## **REQUEST FOR REHEARING**

**Project# PR-2023-006568**  
**Application#**  
**SD-2023-00147 – PRELIMINARY PLAT**

**LOTS 4 AND 5, BLOCK 16 TRACT 3, NORTH  
ALBUQUERQUE ACRES zoned R-1C located at  
9200 WILSHIRE AVE NE between VENTURA  
and HOLBROOK containing approximately  
1.99 acre(s).**

CITY OF ALBUQUERQUE
PUBLIC WORKS DEPARTMENT
ENGINEERING DEVELOPMENT GROUP
WILSHIRE PLACE SUBDIVISION
GRADING AND DRAINAGE
GRADING PLAN

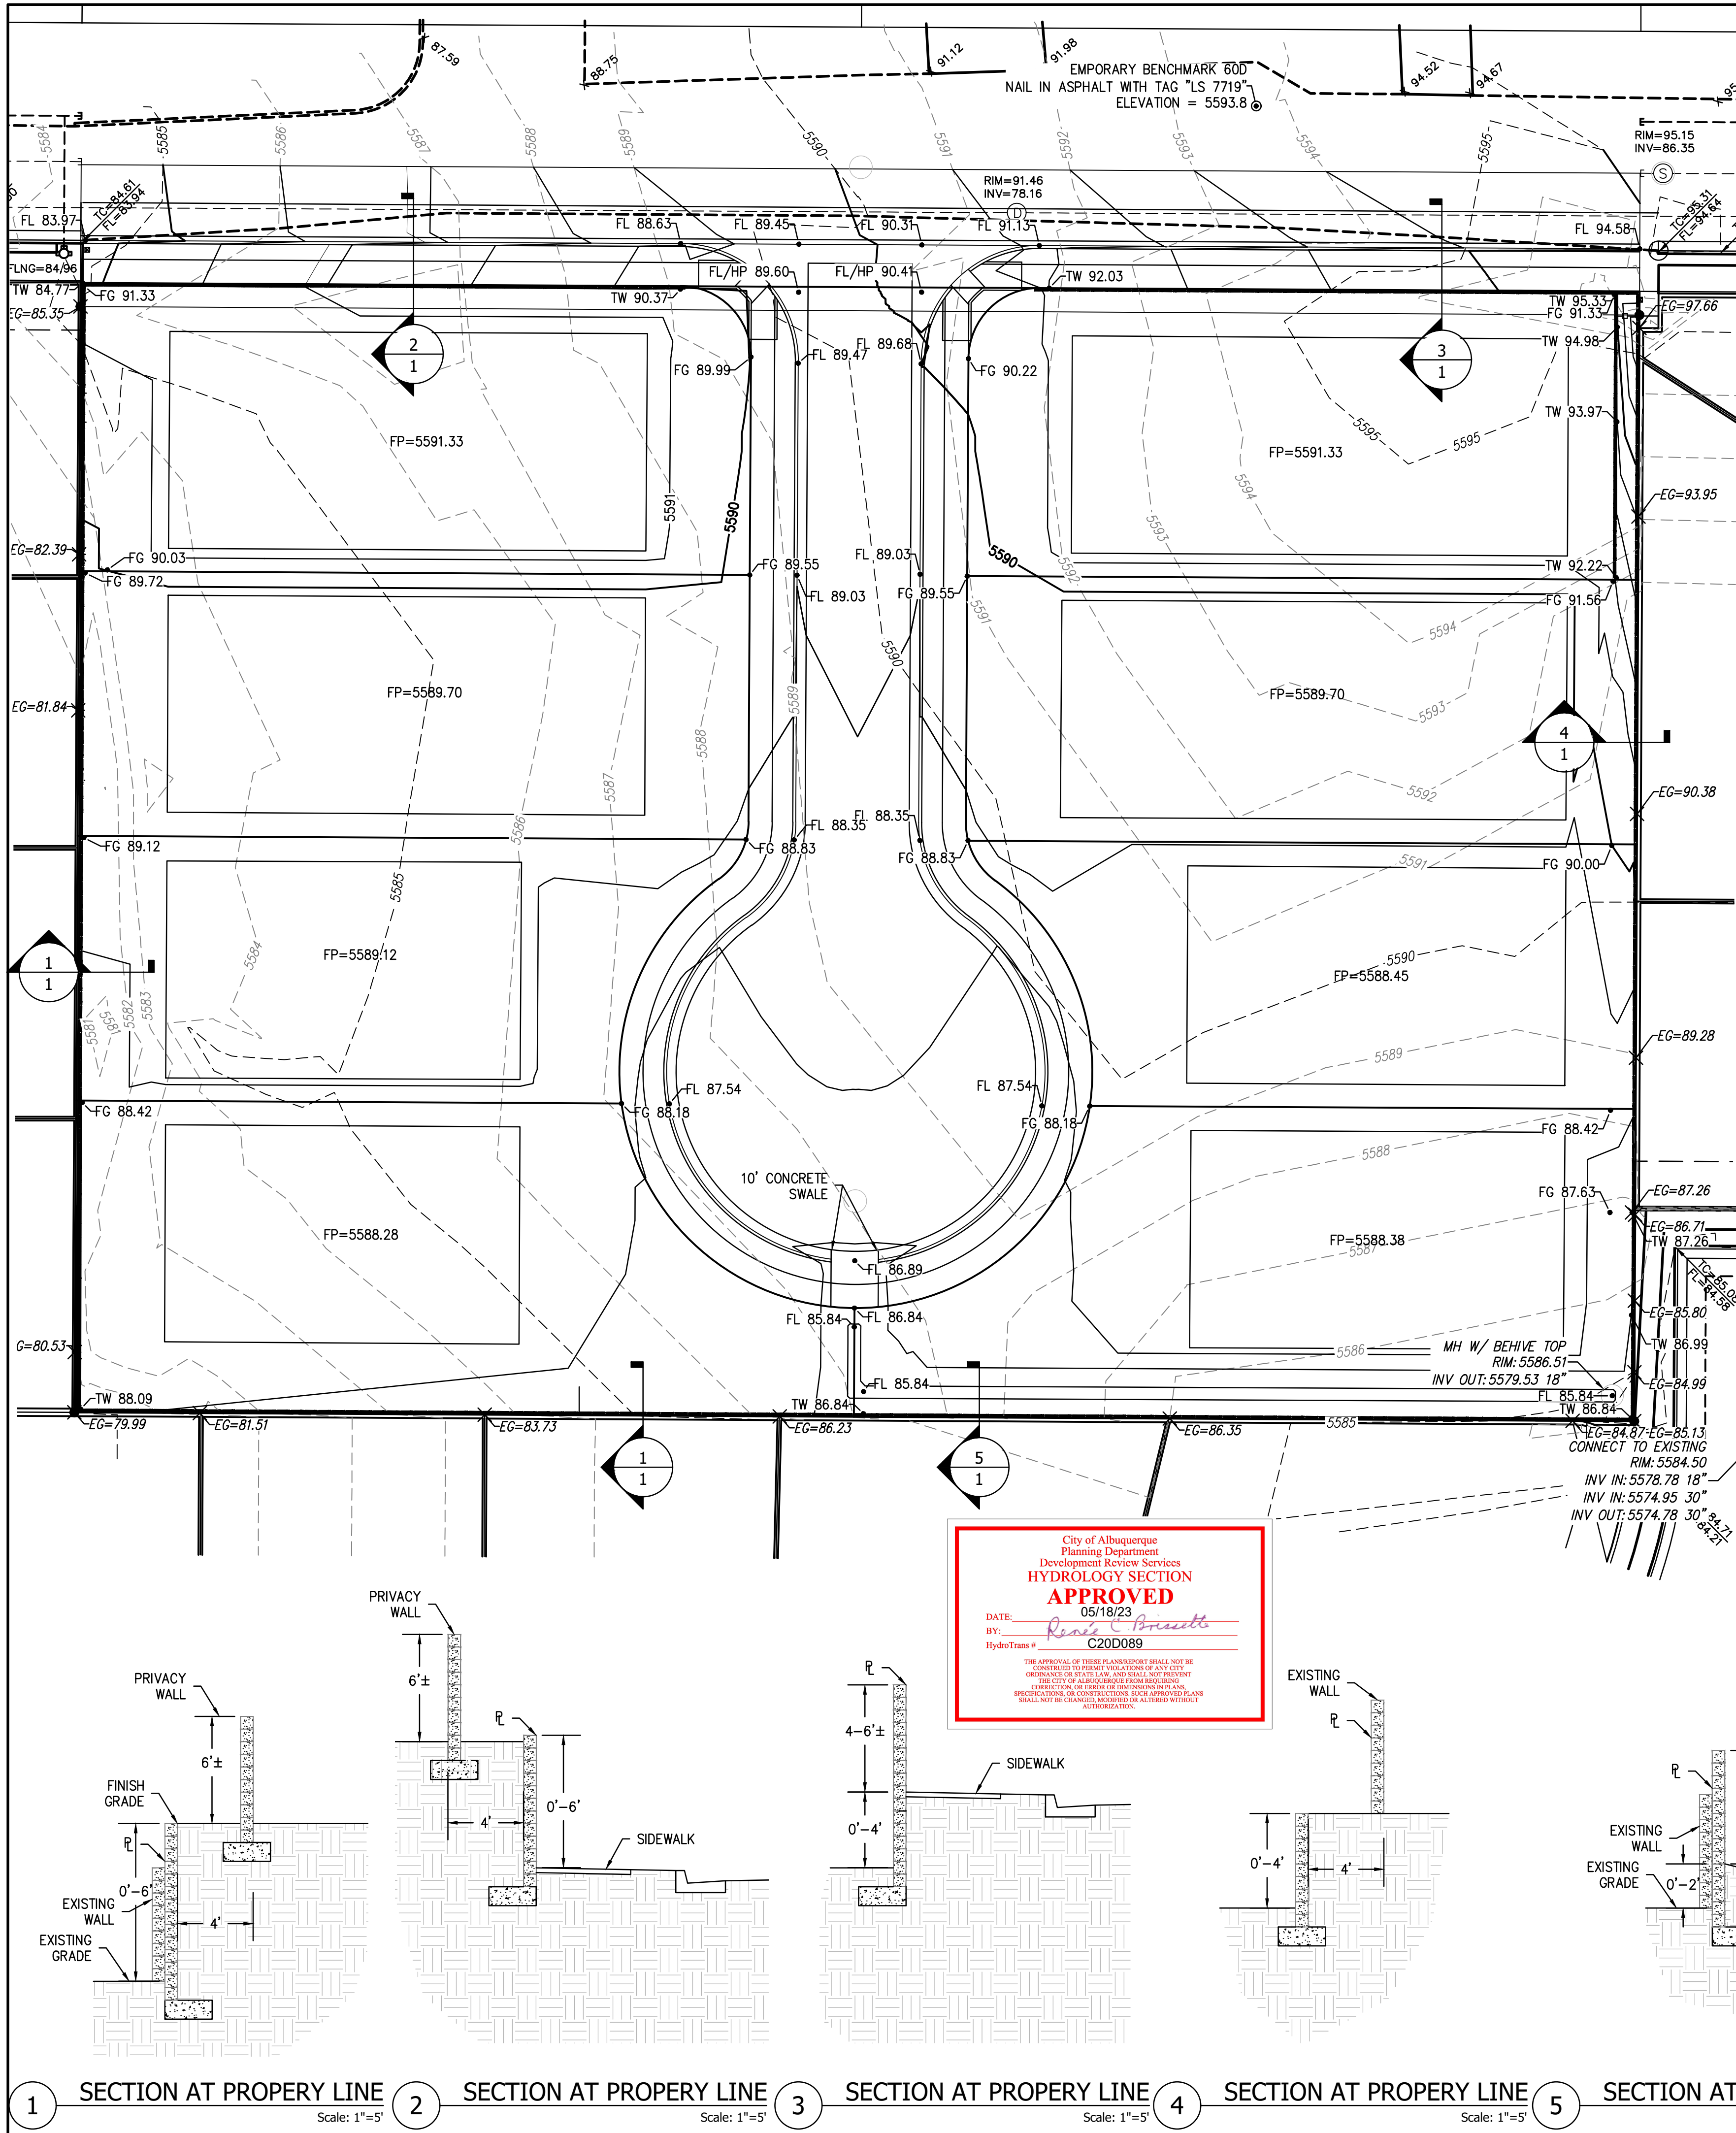
6. The application submittal included diagrams without specific wall heights and instead contained a range of speculative wall heights for retaining walls and privacy walls. The wall height along various perimeters was not clear on the application submittal and ranged from 0 to 6 feet. The IDO limits all wall heights to 3 feet in the front and side yards, and Code Enforcement staff testified in the hearing that, based on the applicant submittals provided, Code Enforcement could not confirm whether or not the walls would require a variance. Upon further review by DFT, some of the walls along Wilshire would exceed the IDO limit of 3 feet and would require some type of variance or special approval. The applicant made no request for retaining or privacy walls to vary from the IDO required limit of 3 feet for the front and side yards and has not submitted any approvals for a variance from this requirement.

7. Per the DHO Rules of Procedure, #3, “Conditions of Approval. The DHO may accept conditions of approval for a plat if it would not result in any material redesign of the project.” The DHO approval of the application stated, “All wall heights and necessary setbacks will be in compliance with the grading plan and the DPM per the IDO. In the event that a variance is needed, then the Preliminary Plat will need to be reapplied for.” The application needs a variance for wall heights shown for front and side yards on Wilshire and a material redesign may be necessary for the subdivision.

9. The applicant’s evidence and testimony regarding wall heights did not meet the applicant’s burden of showing compliance with required IDO standards.
